## Department of Transportation

March 26, 2021

RE: Helton Amended Site Plan - South Academy Business Park\_ SH85.87

SOUTH ACADEMY BUSINESS CENTER 4425 HWY 85-87 EL PASO COUNTY, COLORADO SITE DEVELOPMENT PLAN

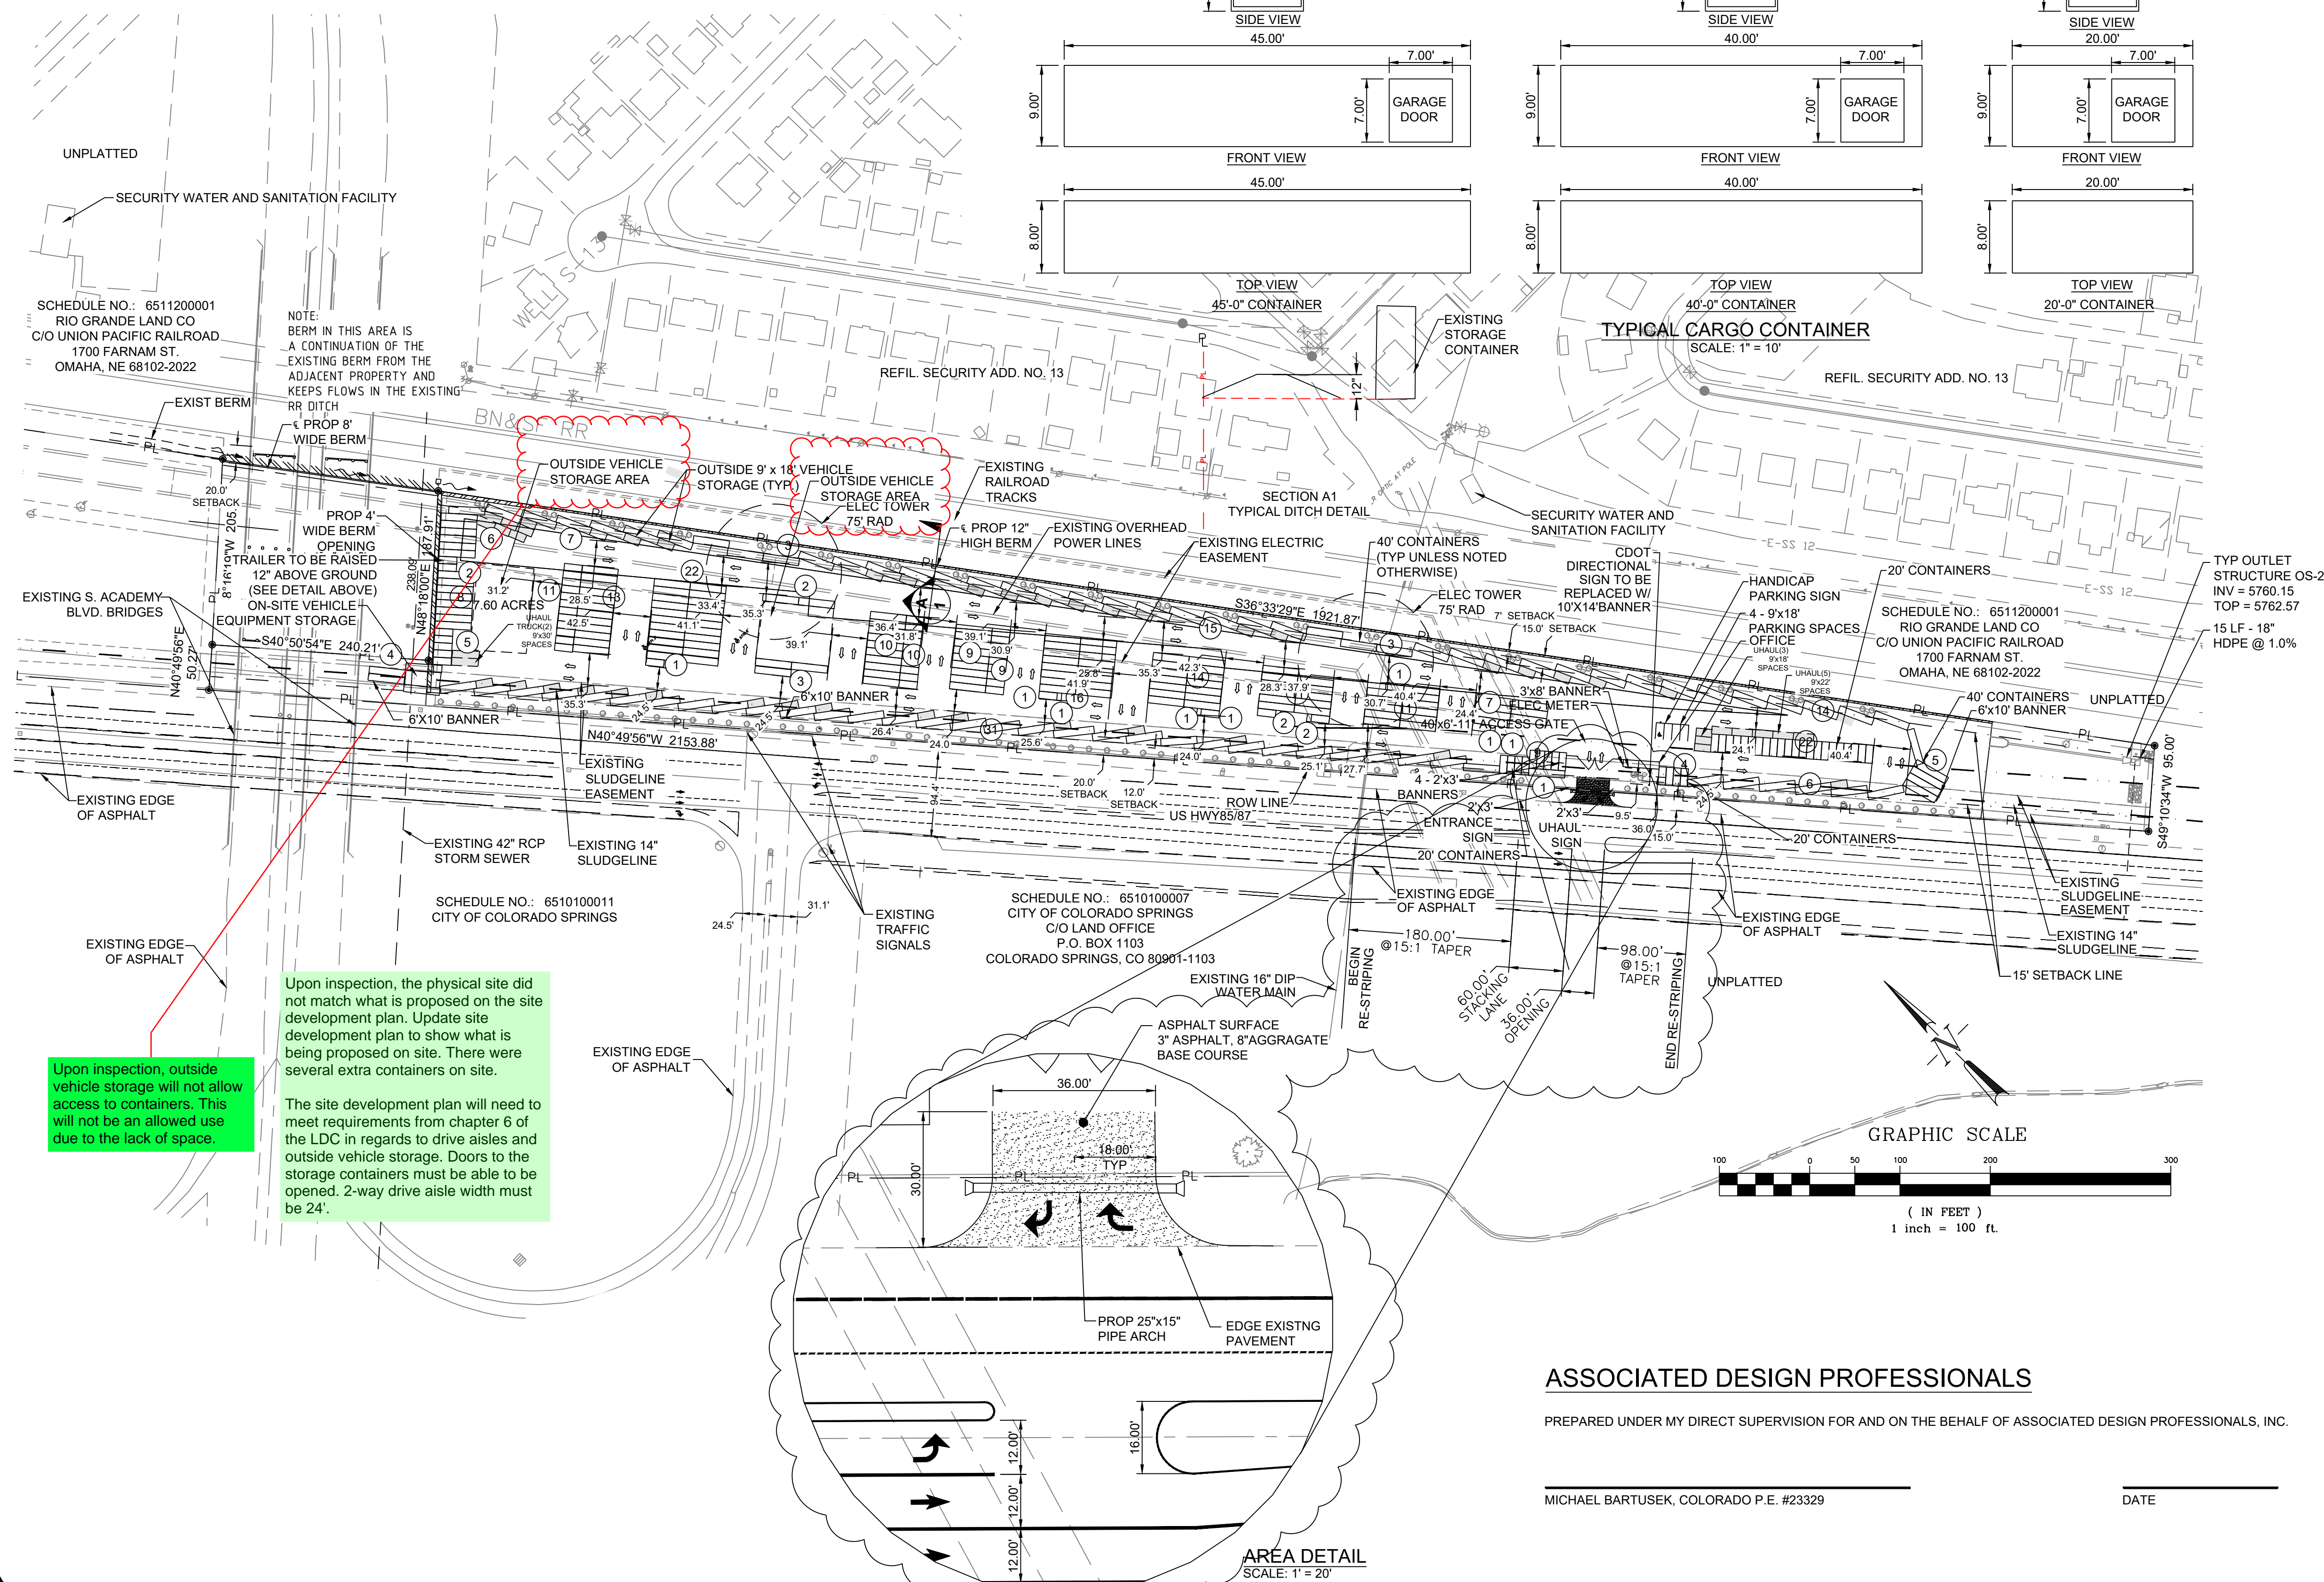
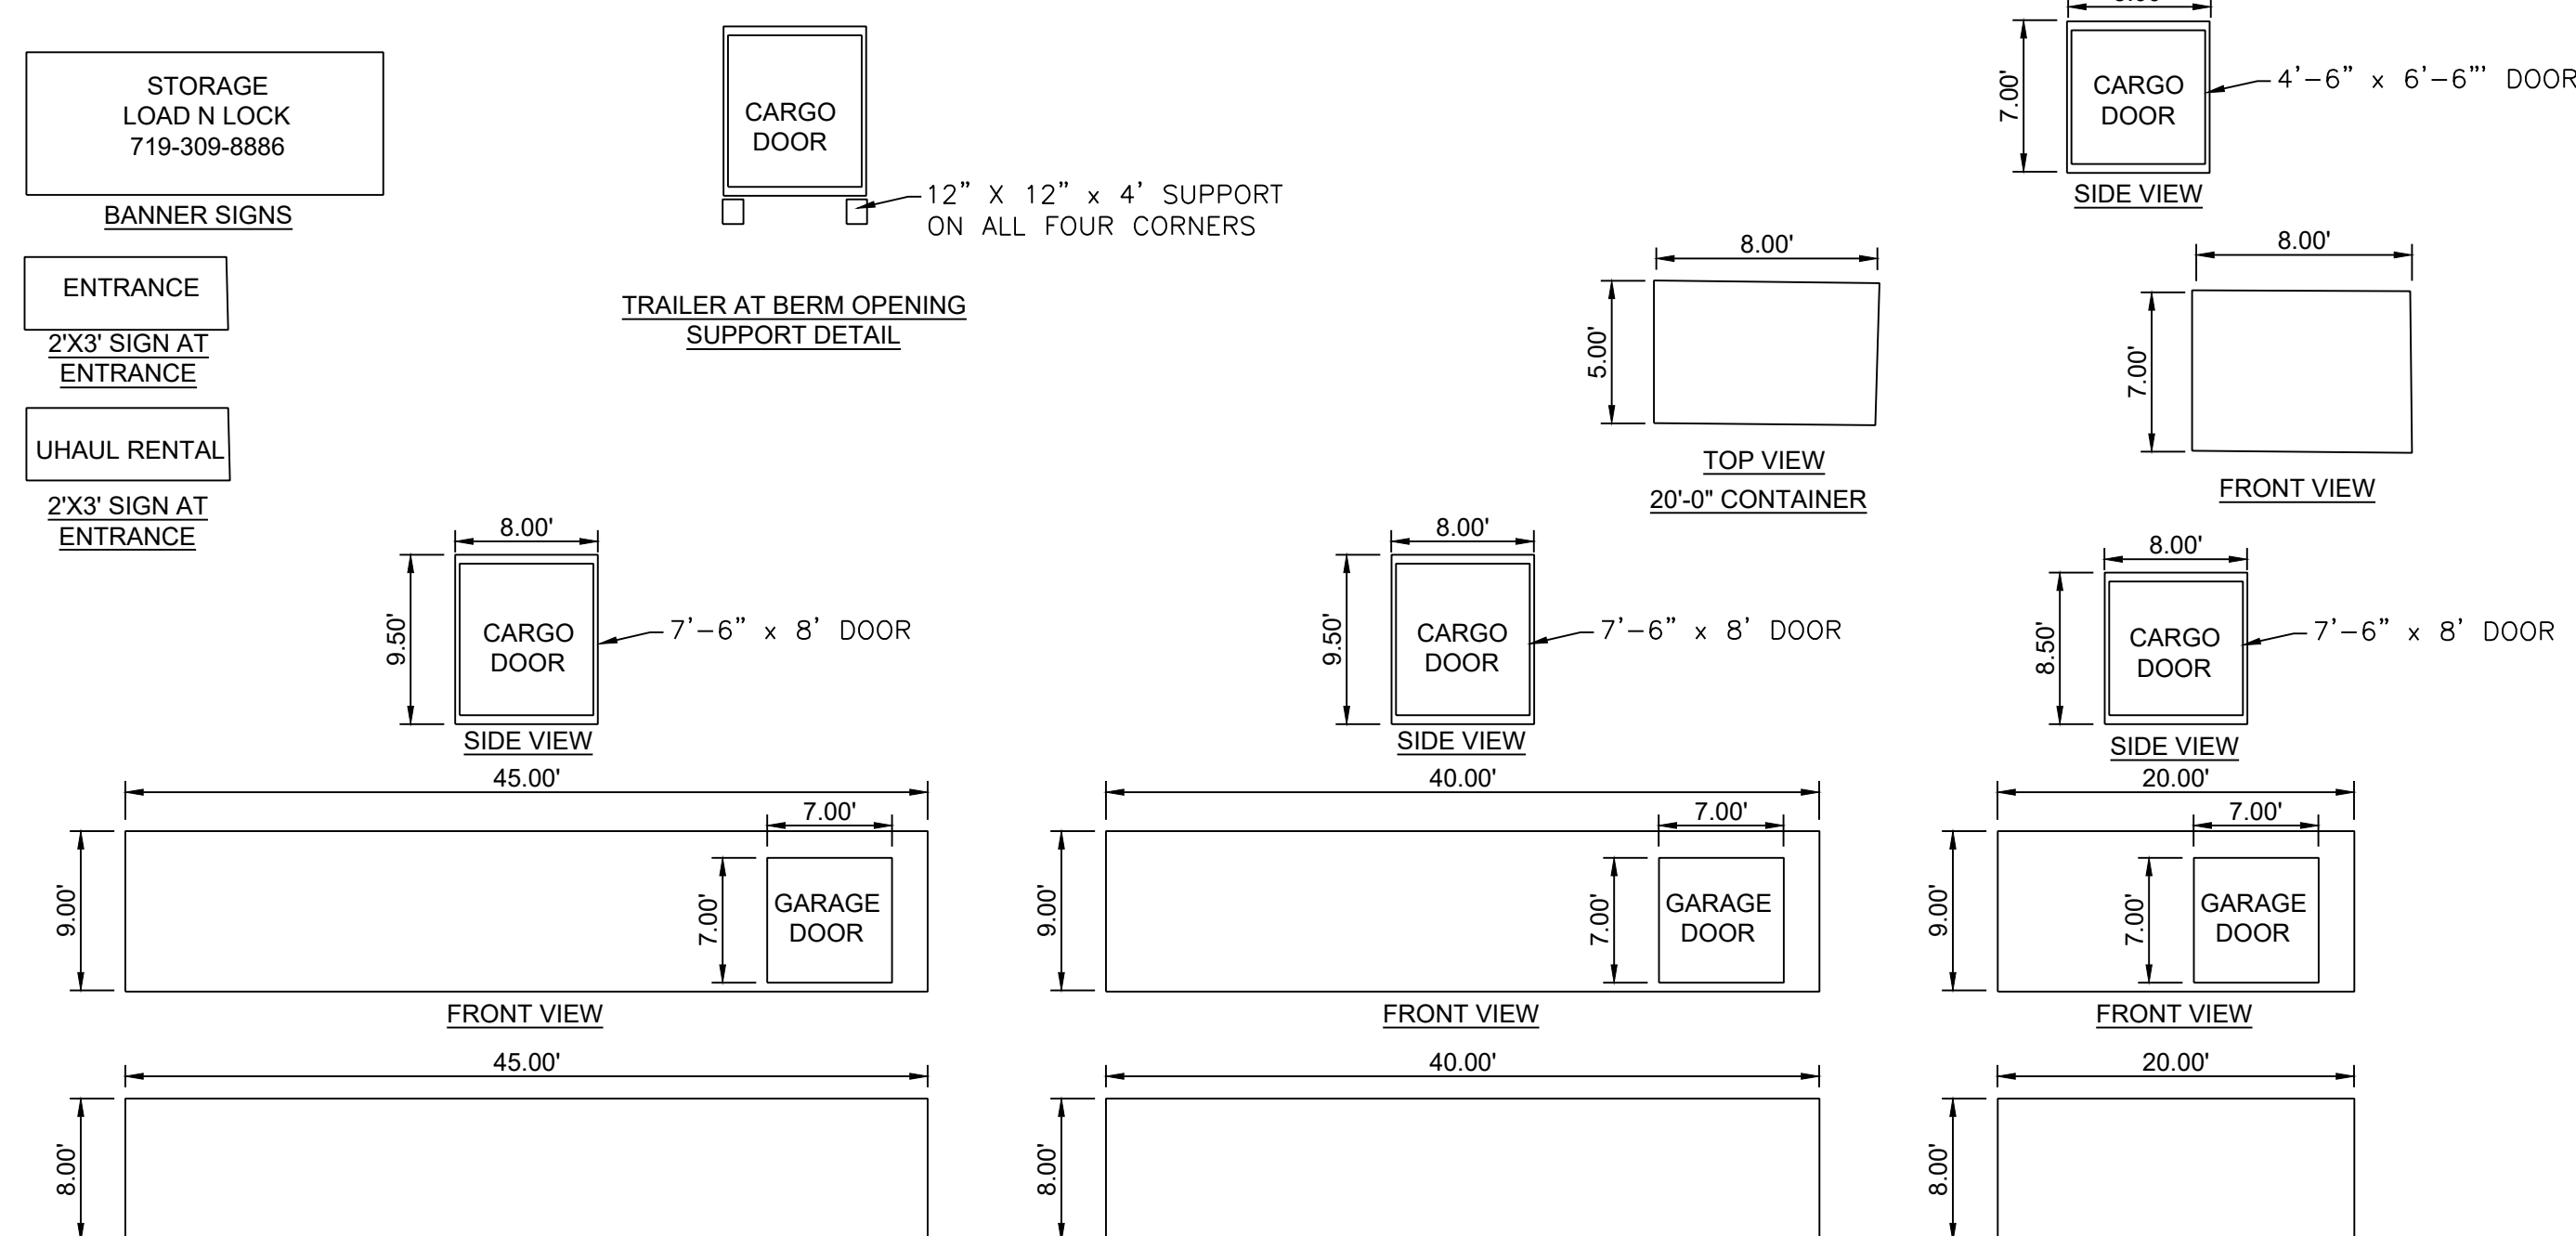
- CDOT Access Dept. comments are as follows:
  - a. The developer is required to apply for a new Colorado Department of Transportation Access Permit to document the new roadway improvements proposed.
  - b. No additional access from SH85/87 will be permitted to the site.
  - c. Review of the acces permit AP218005 from CDOT mentions that Right In/Right Out traffic movements are the only allowable traffic movements until such a time of expansion or redevelopment which requires a new access permit, roadway improvements to SH85/87 and a centerline non-traversable median was required.
  - d. A more detailed roadway drawing or plan is being requested for review.
